DEVELOPMENT REVIEW BOARD
TRANSPORTATION DEVELOPMENT

DRB Project Number: 1008830
Town of Atrisco

SUBJECT: Amended Site Plan for Building Permit

DRB Project Number: 1008830 Hearing Date: 04-11-2018
 Project: Paradise RV Park – Phase I Agenda Item No: 2

SITE DEVELOPMENT PLAN FOR BUILDING PERMIT

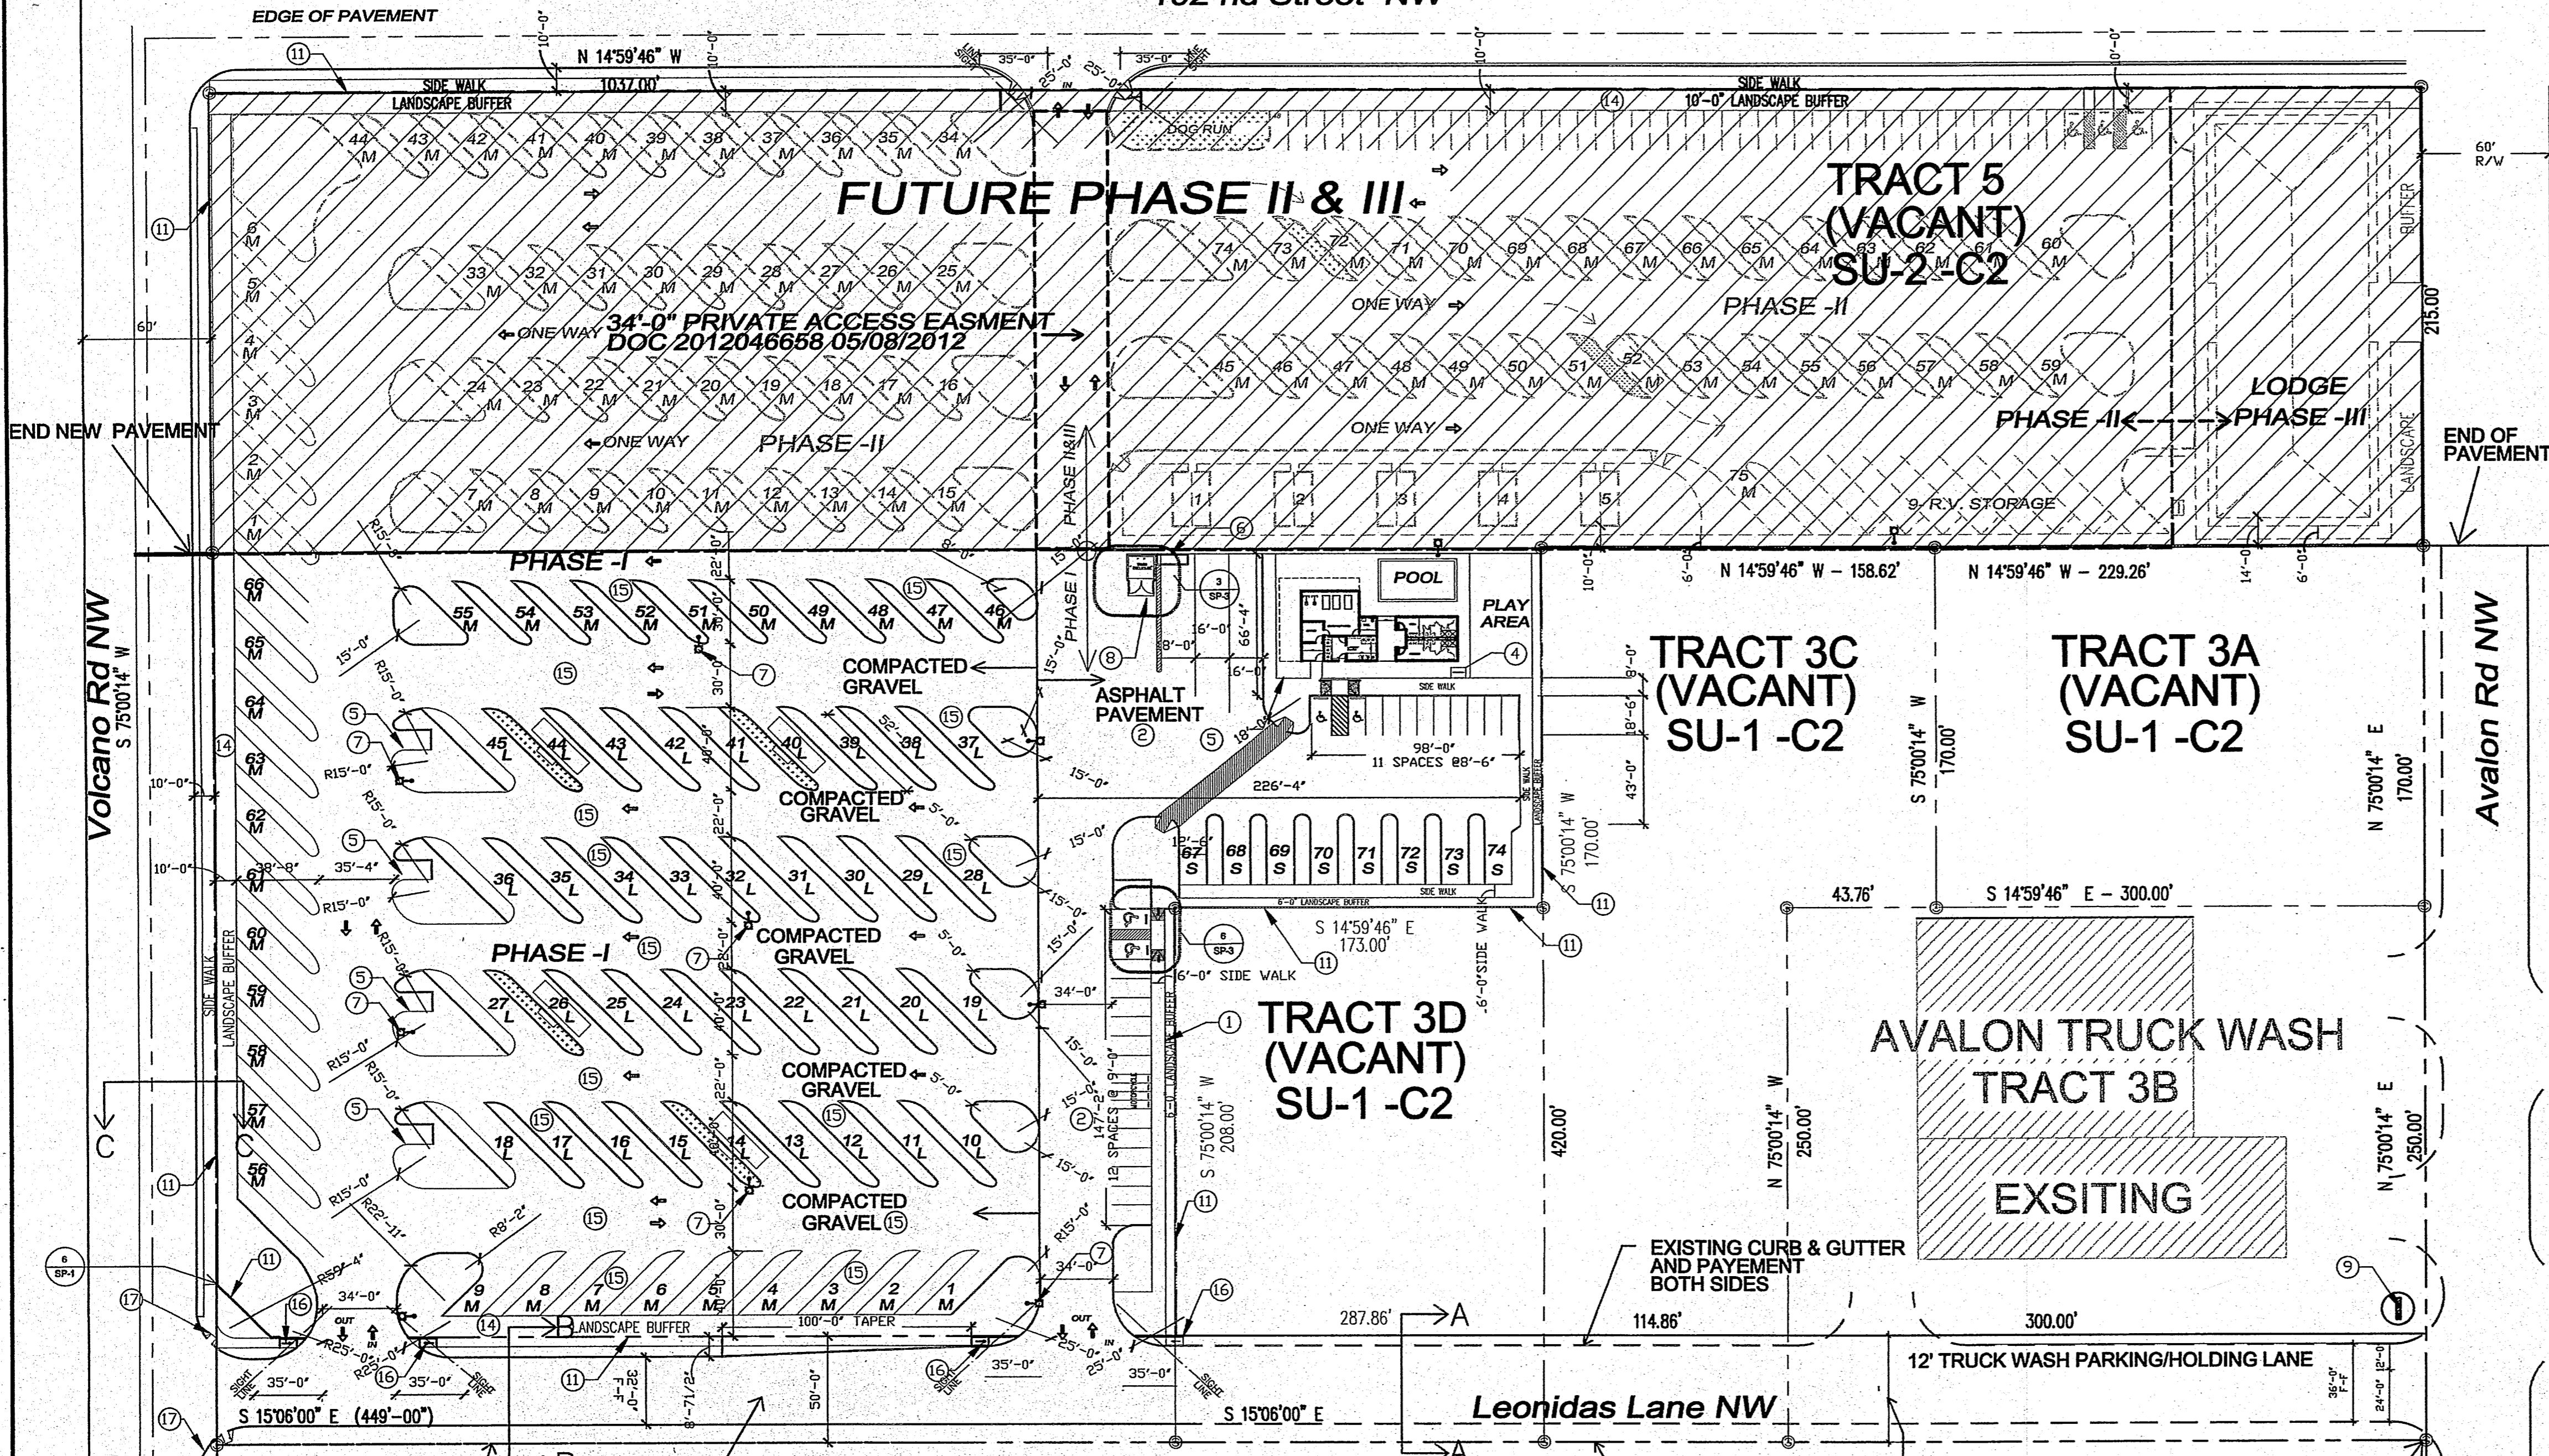
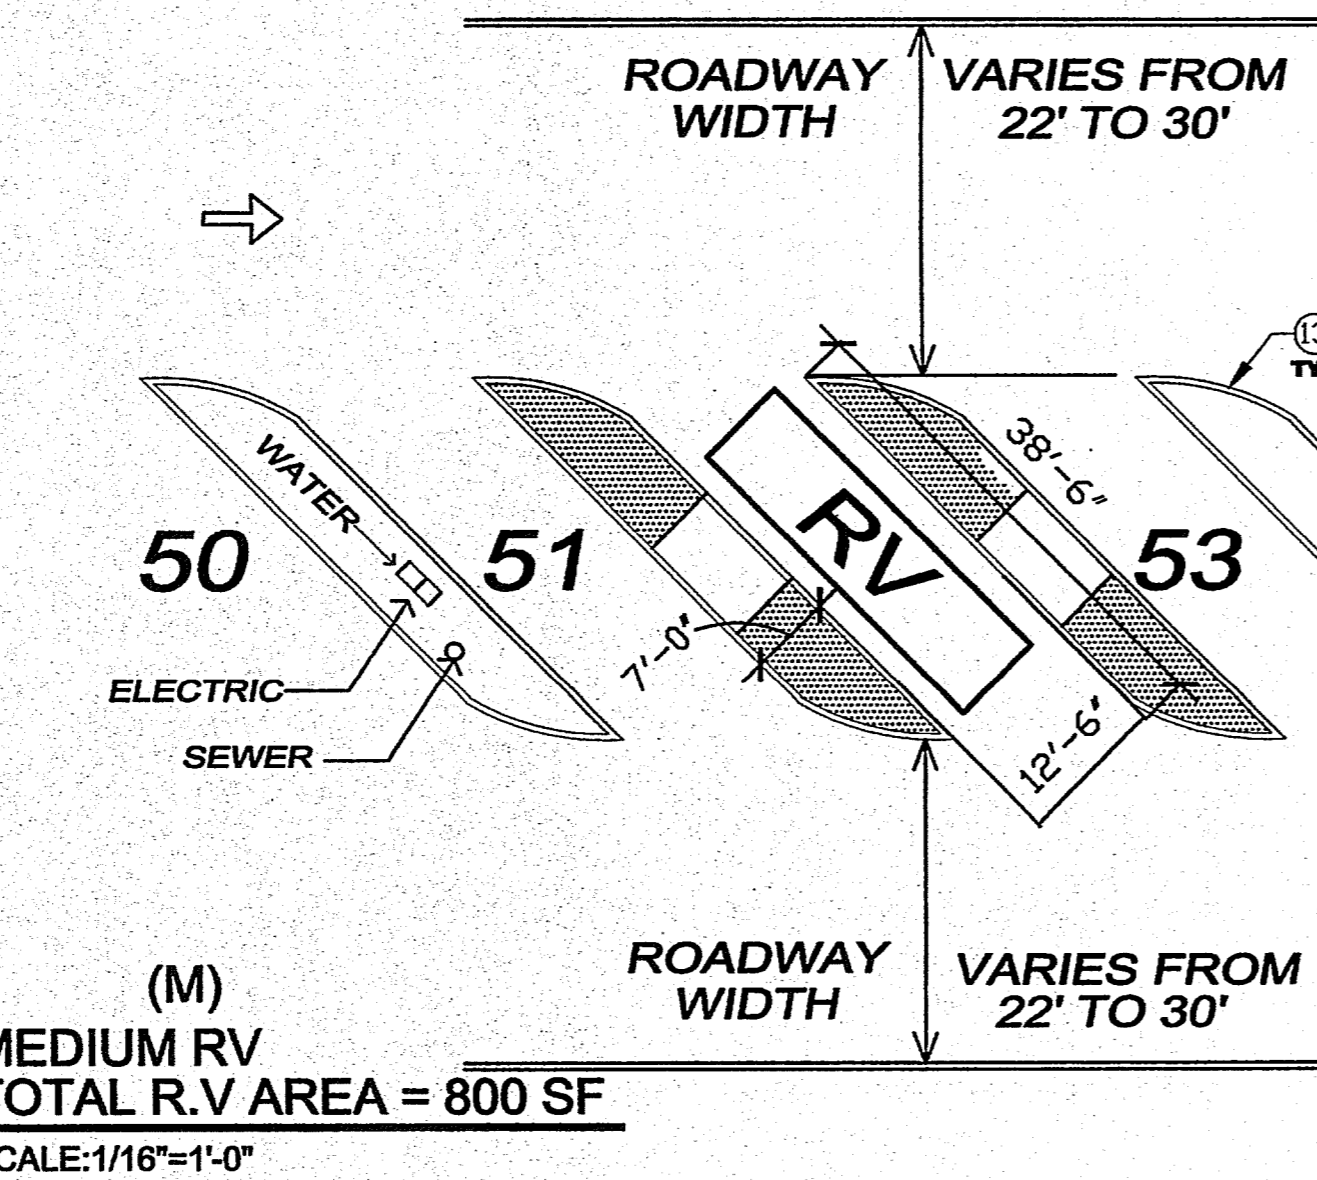
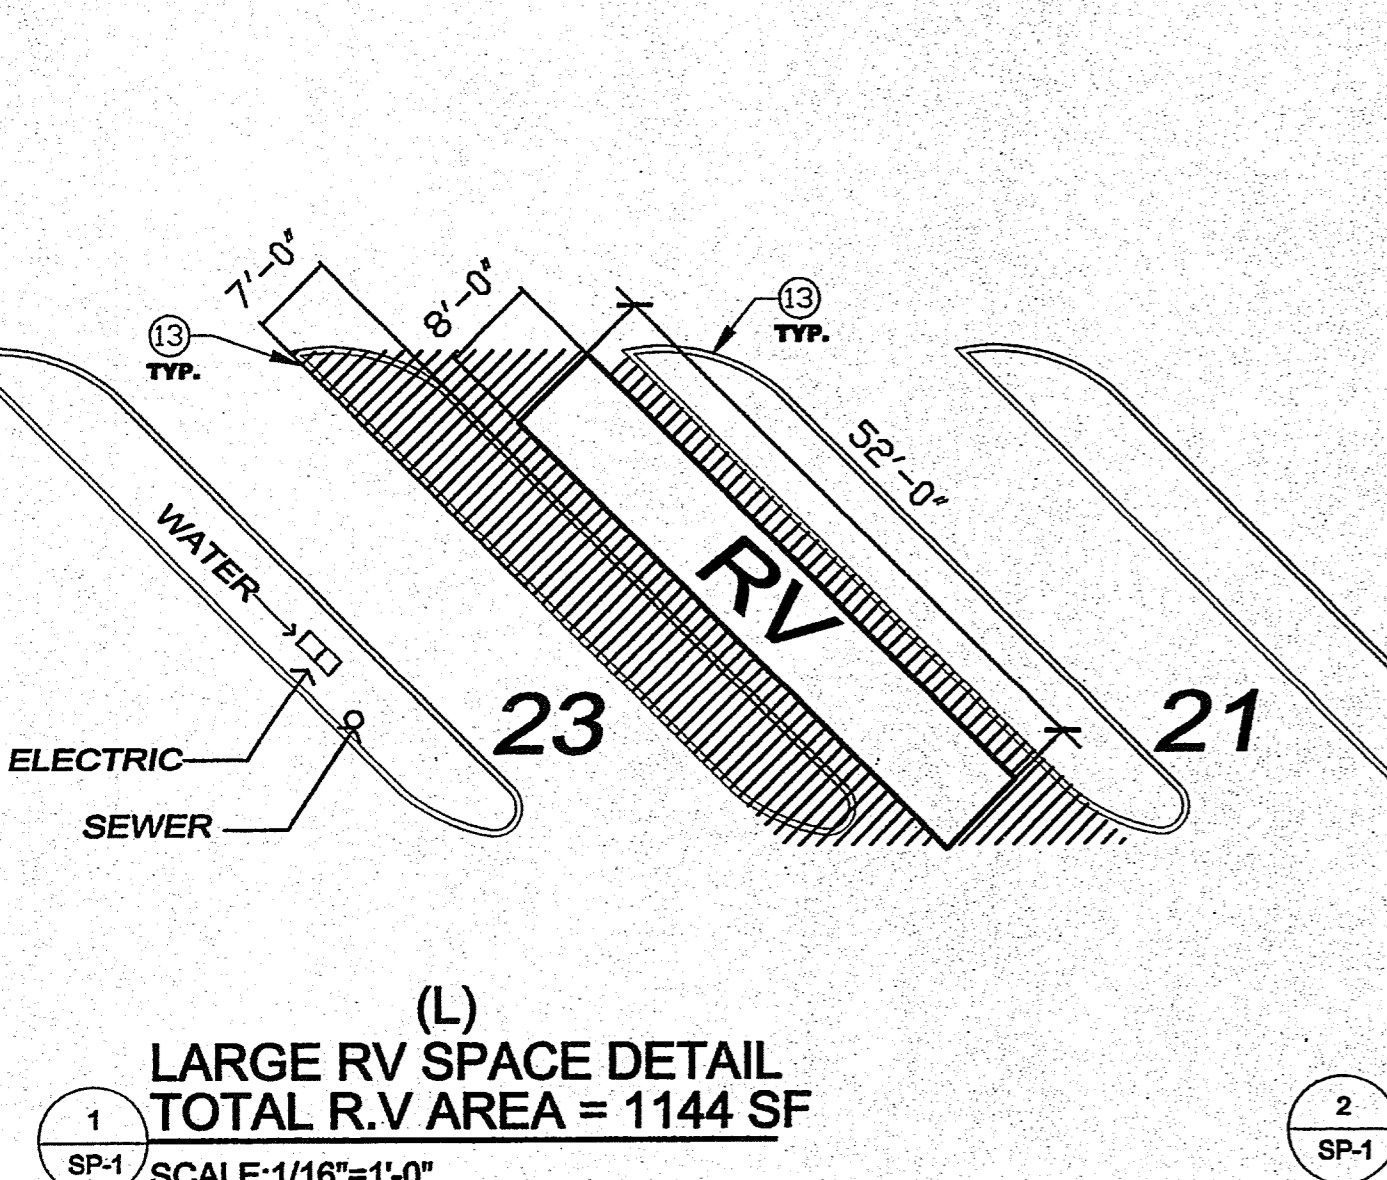
- The word "TOW" on the IL should be Row (according to the previously approved IL).
- The site plan that was submitted is not the signed off copy. Was the SDPBP signed off? If not it needs to be (by the DRB)
- Must have a signature line for Code Enforcement.
- Original must be signed by the Engineer.
